# **ERRATA SCHEDULE: 9.1**

## **Cory Decarbonisation Project**

PINS Reference: EN010128

**September 2024**

DRAWING NUMBER:
EN10128-WSP-00-XX-PL-ENS-0001-P01

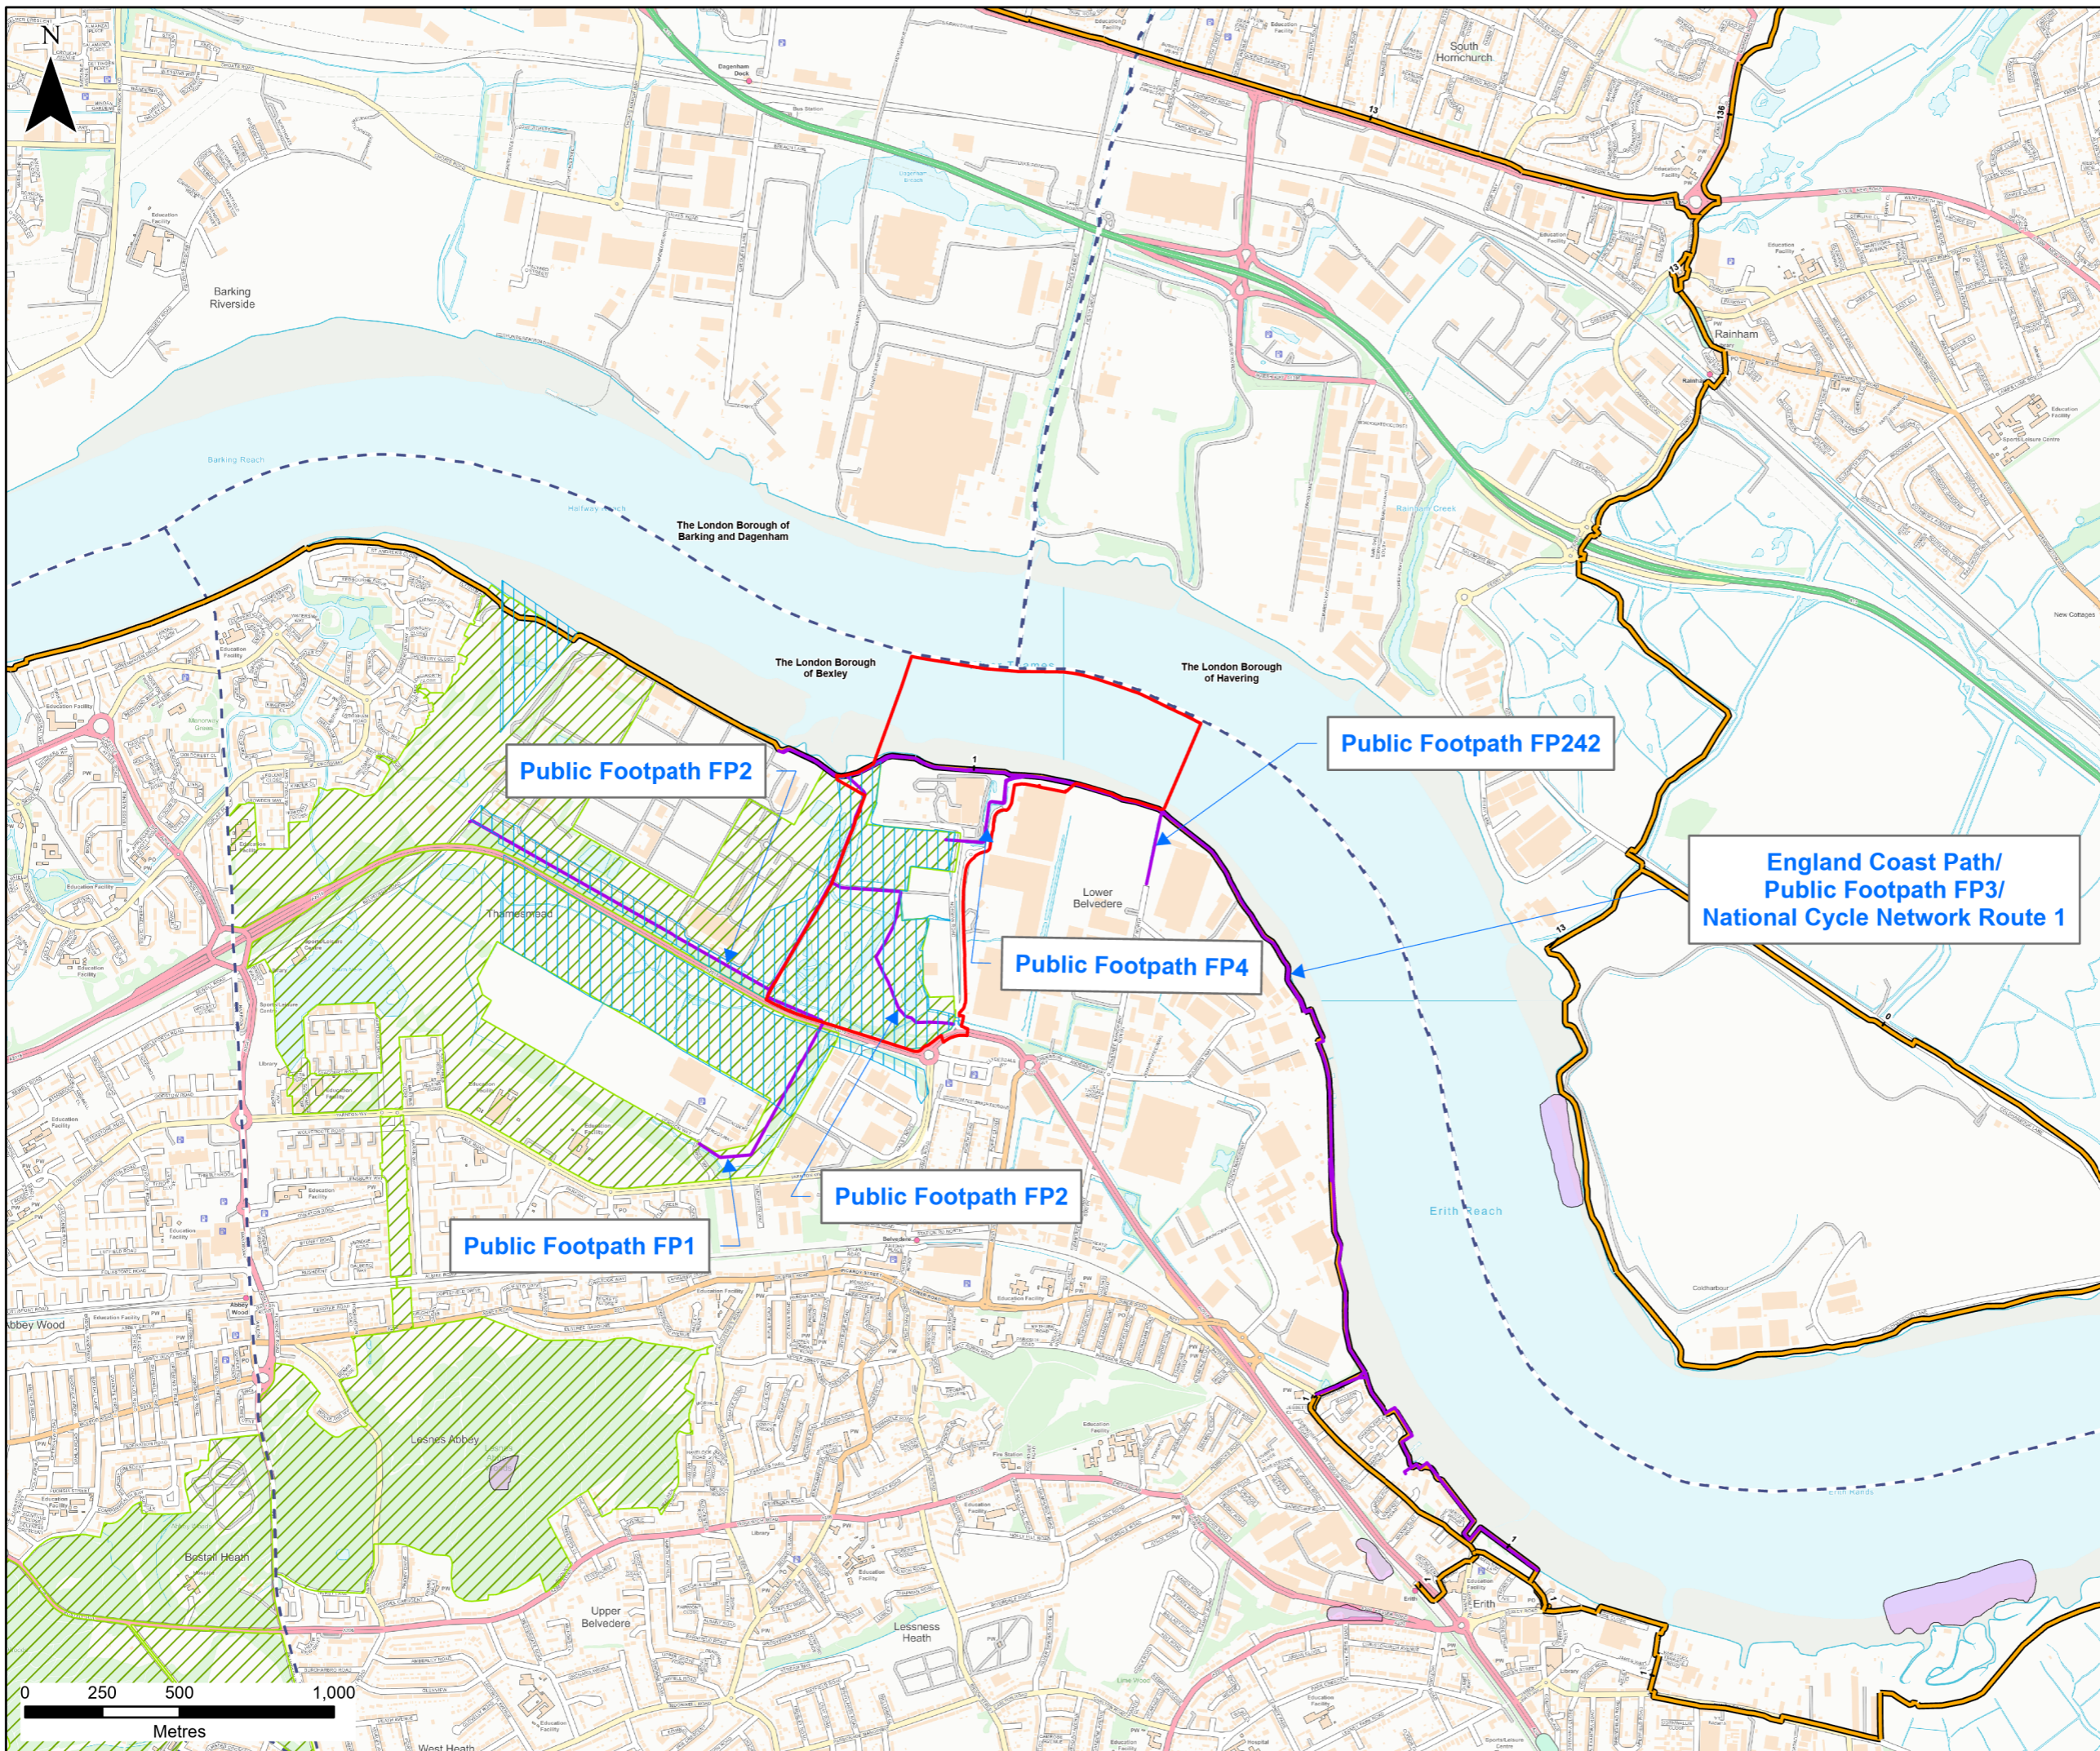
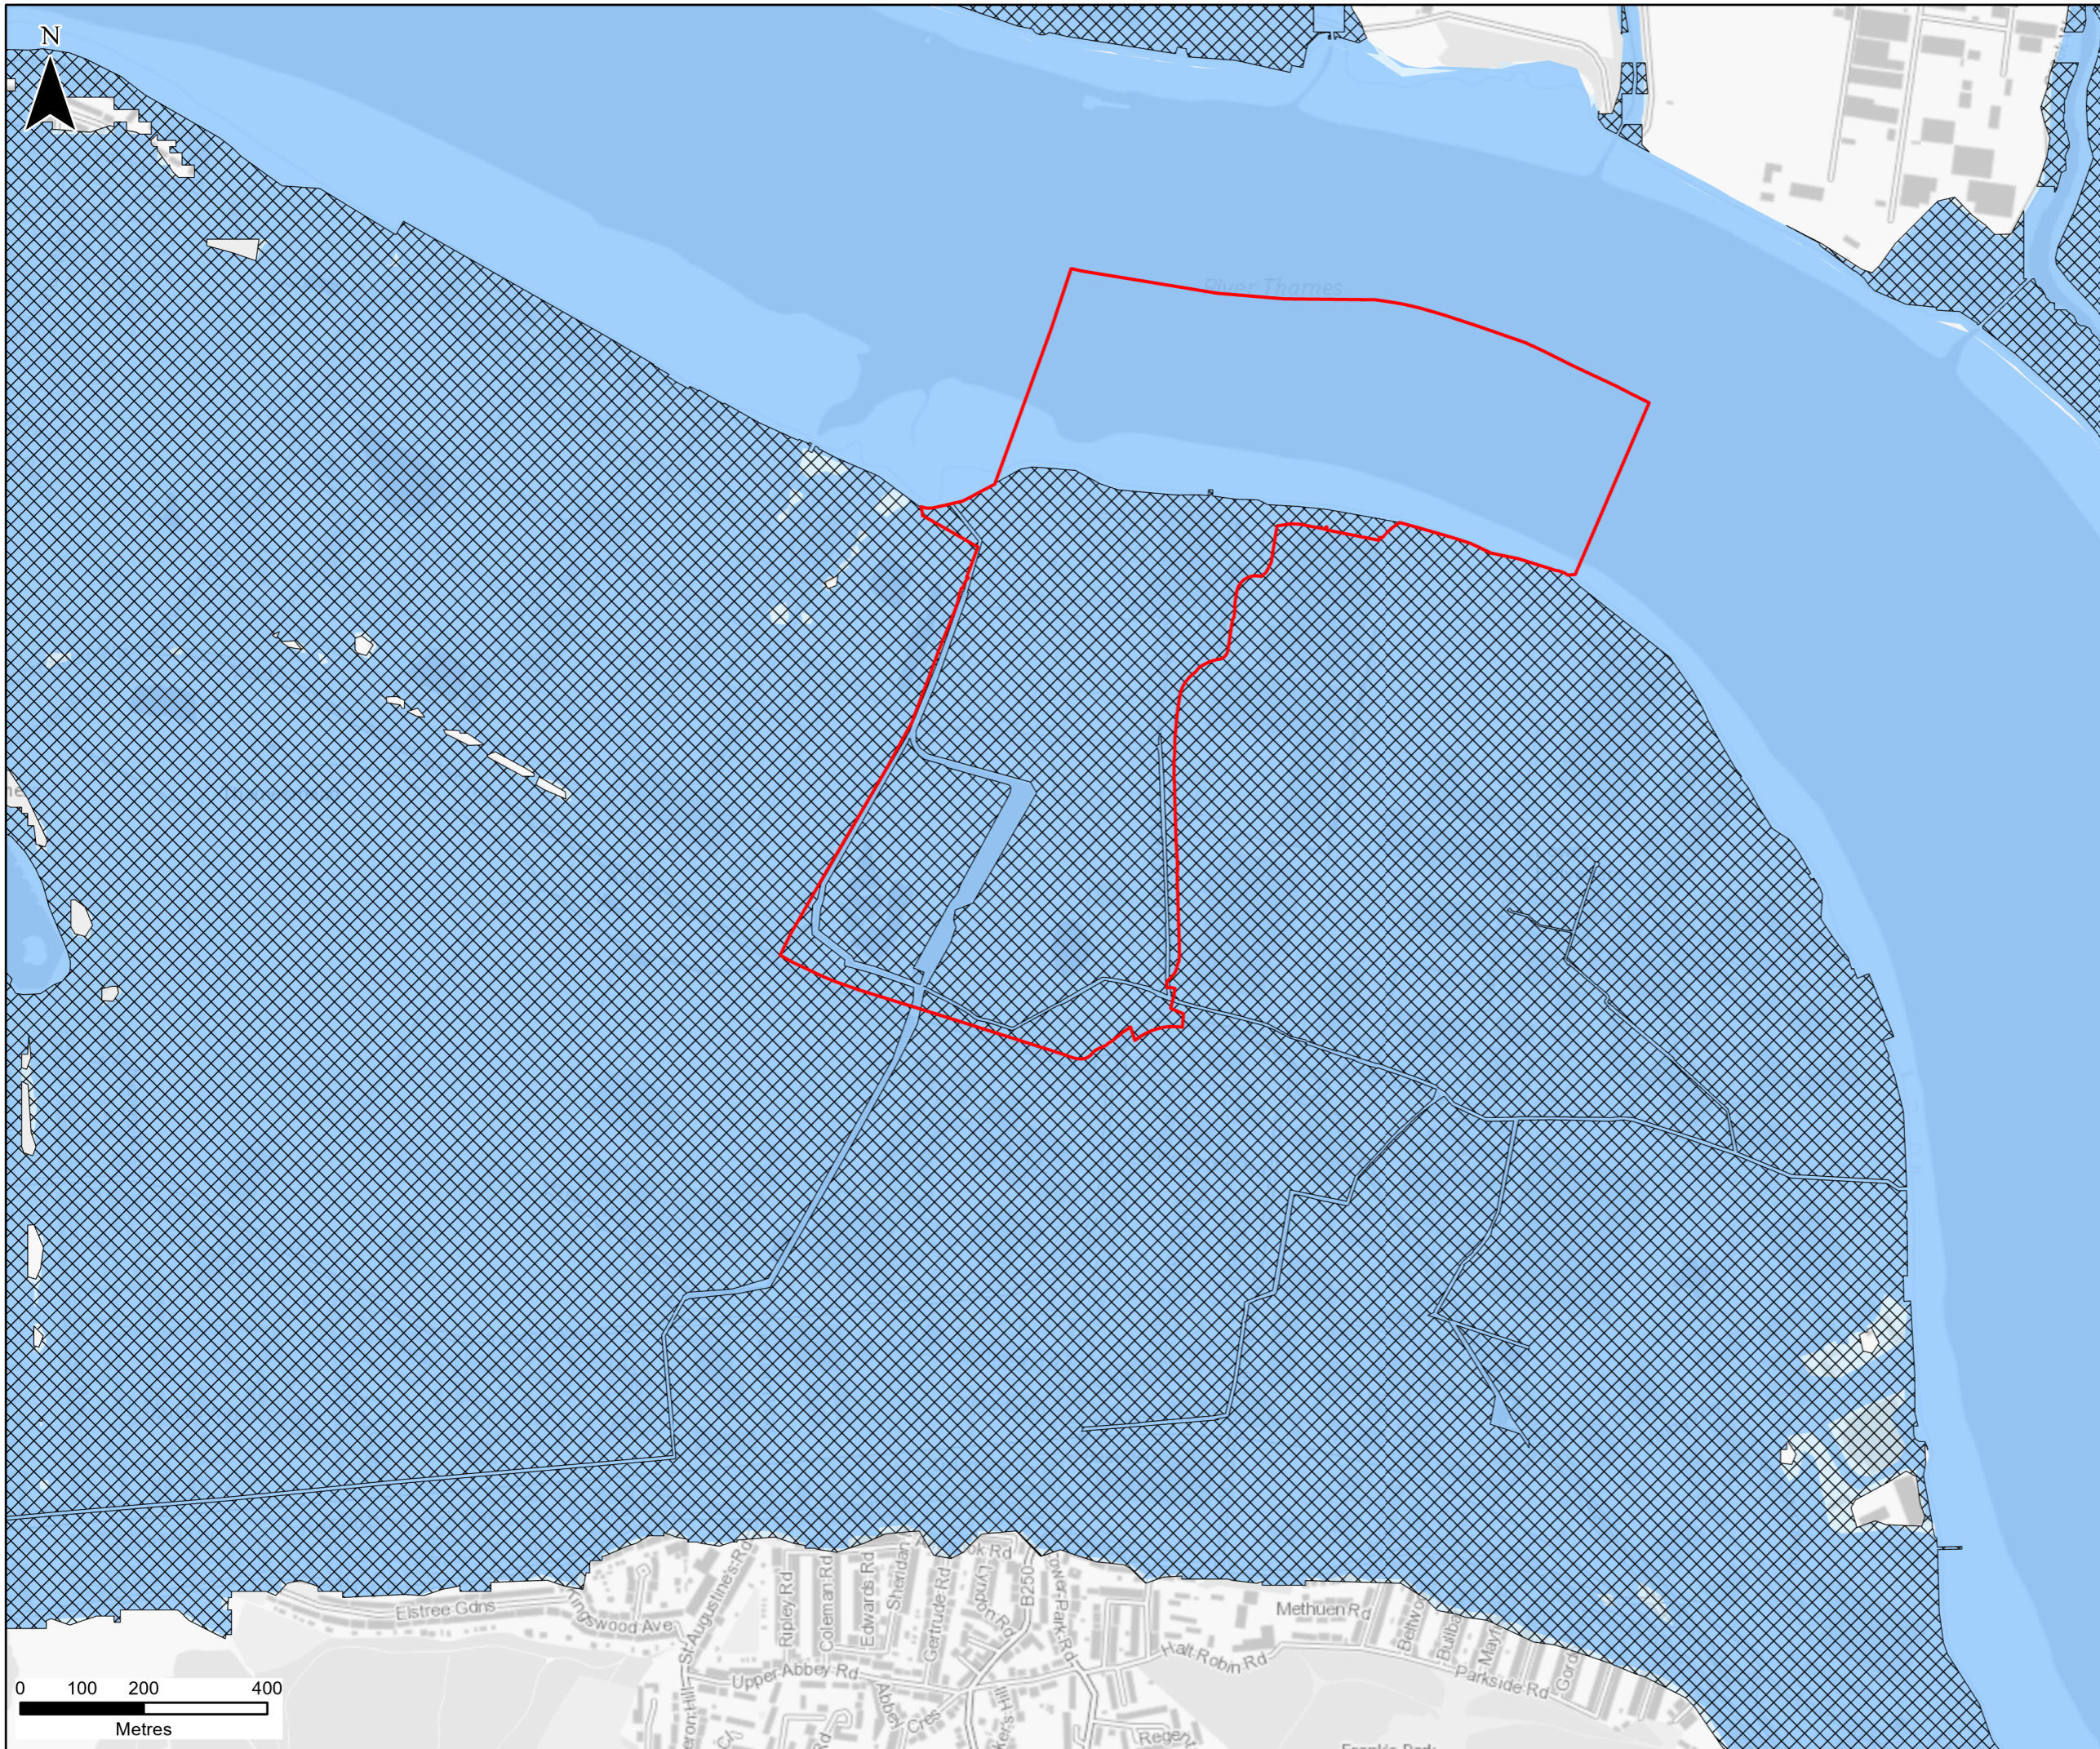
Document Reference	Planning Inspectorate Reference	Page / Paragraph / Table / Plan / Figure Reference	Error	Correction
		Marine Plan/ Topic: Ports, harbours, and shipping Policy Code: SE-PS-2/ Table 1-2	<i>“In response to Policy SE-PS-2: The Site does not fall in or encroaches upon International Maritime Organization routeing system; therefore, the Applicant considers SE-DEF-1 is not relevant to the Proposed Scheme.”</i>	<i>““In response to Policy SE-PS-2: The Site does not fall in or encroaches upon International Maritime Organization routeing system; therefore, the Applicant considers SE-PS-2 is not relevant to the Proposed Scheme.”</i>
		Marine Management Organisation (MMO): South-East Inshore Marine Plan/ Topic: Climate Change Policy Code: SE-CC-1/ Table 1-2	Incorrect figure reference: <b>“Figure 2-2: Environment Constraints Plan – Flood Zones (Volume 2) of the ES (Document Reference 6.2)”</b>	Correct figure reference: <b>“Sheet 2: Flood Zones of the Environmental Features Plans (Document Reference 2.7)”</b>
